From: Prilucik, Jacob <PrilucJ@wsdot.wa.gov>
Sent: Thursday, July 21, 2016 2:19 PM
To: Jeff Watson; Kelly Bacon; Doc Hansen
Cc: Gonseth, Paul; Holmstrom, Rick
Subject: RE: Notice of Application: CU-15-00007 NW Chimpanzee
Attachments: 201607211300.pdf

Cc: Doc Hansen
Subject: Notice of Application: CU-15-00007 NW Chimpanzee

Kittitas County Community Development Services has received the above referenced application for a Conditional Use Permit to operate a school east of Cle Elum on Highway 10 in the upper county. See attached documentation for additional information or use one of the hyperlinks above to access the on-line or network file. Comments within the body of an email are encouraged but may be sent as attachment or via USPS as a hard copy.

10/21/2015

SITE PLAN

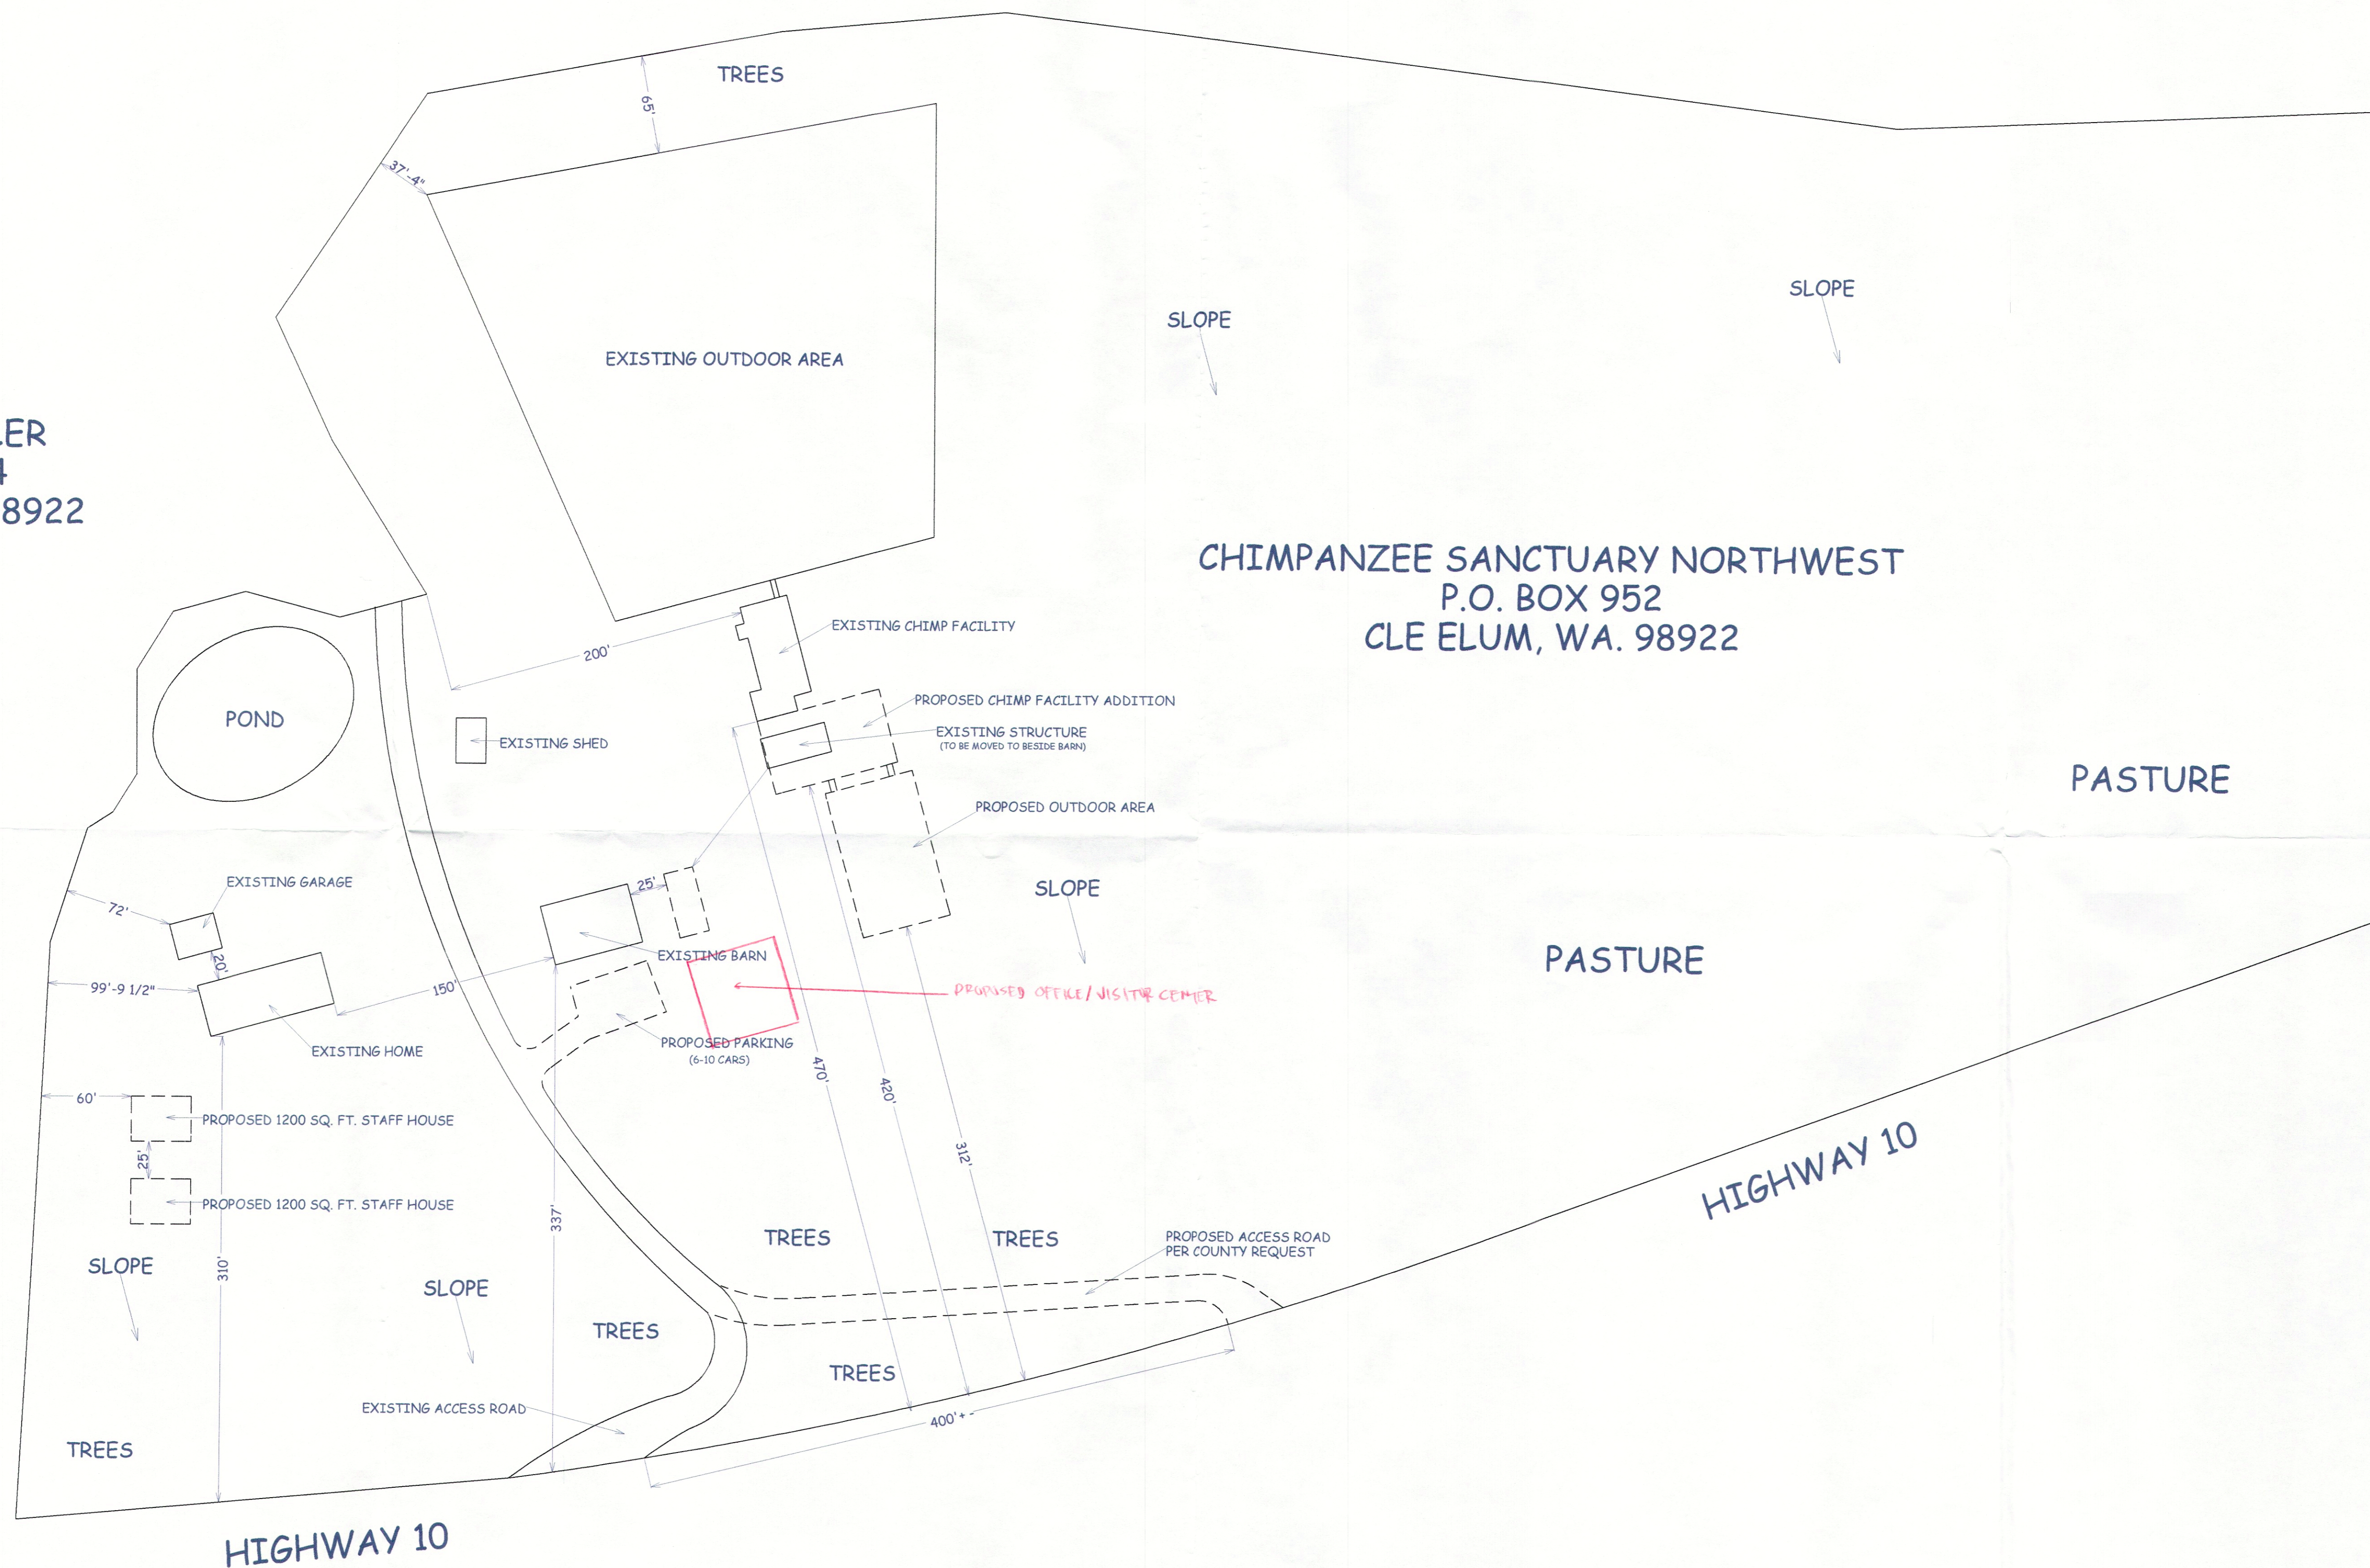
Comments: *Must ~~have~~ ^{have} adequate fire apparatus access, fire sprinklers required, fire alarm to be monitored, exterior siding/materials to meet wildland-urban interface requirements. Sprinklers required only in new office building*

Comments: *Fill and Grade permit required. WSDOT access approval needs to be submitted prior to building permits. Storm water plan needs to be approved by County Engineer.*

Comments: *A WFI (water facility inventory) form needs to be completed to update numbers. Current water samples will be needed. Look at current on-site sewage system to see if any changes need to be made with additional chimps population added to the ^{existing} system. HD*
